CITY OF ALBUQUERQUE

Re: GAHP INCA
3701,3705,and 3711 Inca St. NE
Traffic Circulation Layout
Engineer's/Architect's Stamp **05-17-19** (G21D044)

Based upon the information provided in your submittal received 05-31-19, the above referenced plan cannot be approved for Building Permit until the following comments are addressed:

TRAFFIC CIRCULATION LAYOUT

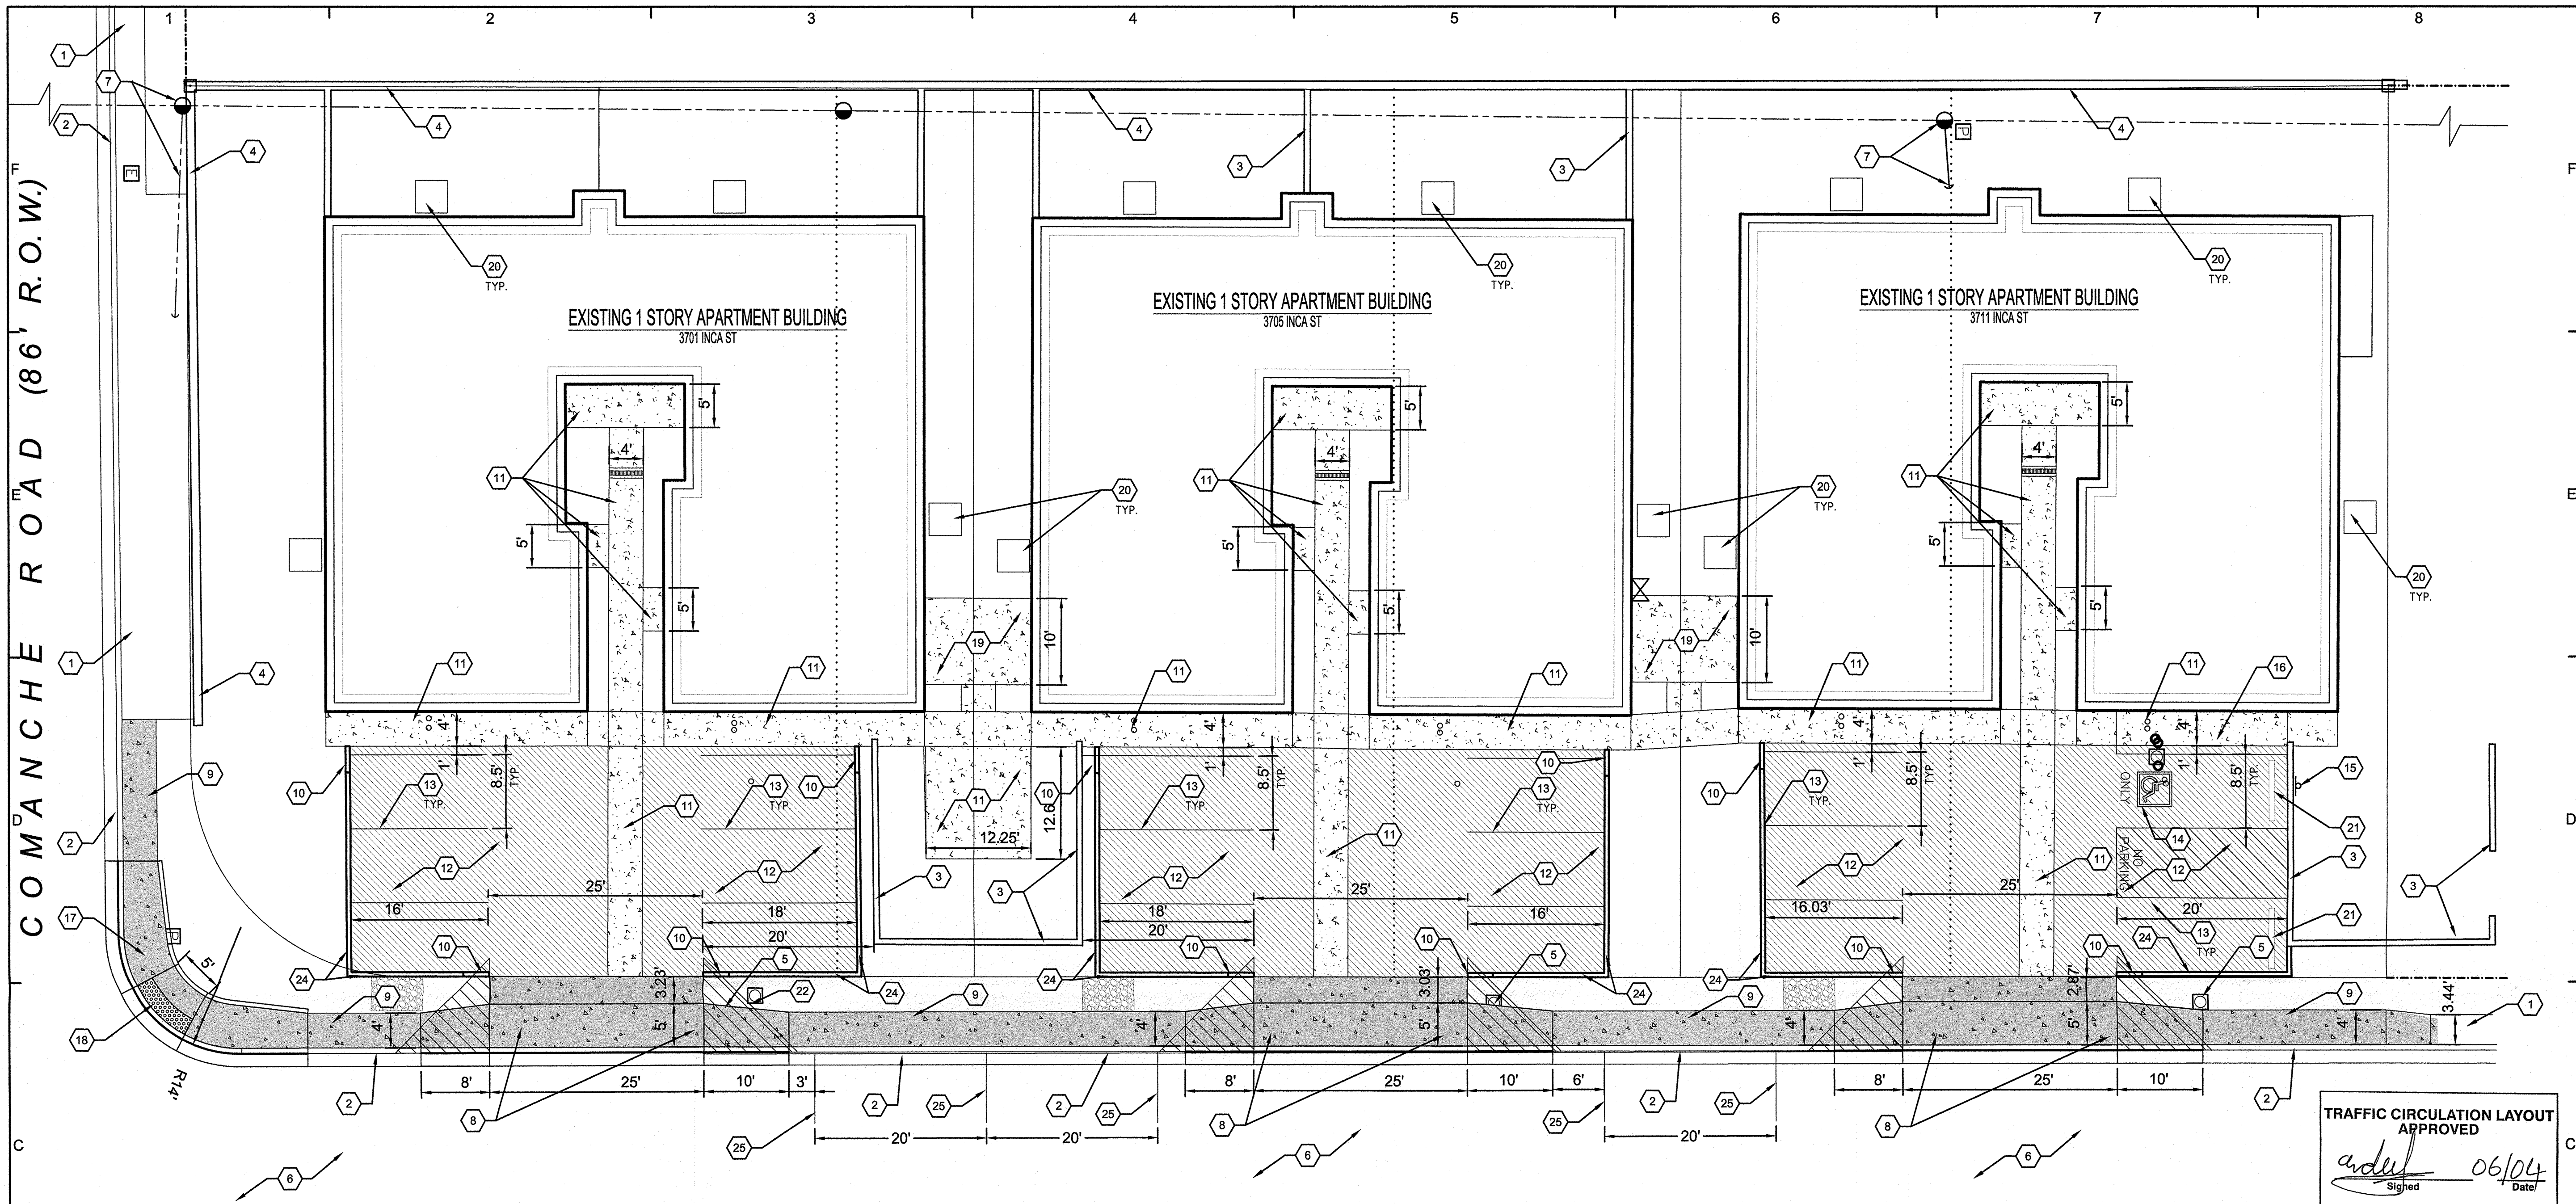
1. Please remove the asphalt removing section "10" from TCL. That part requires a mini work order.
2. For keyed note # 8 please use NMDOT standard.
3. Identify the on-street parking along with its dimension.
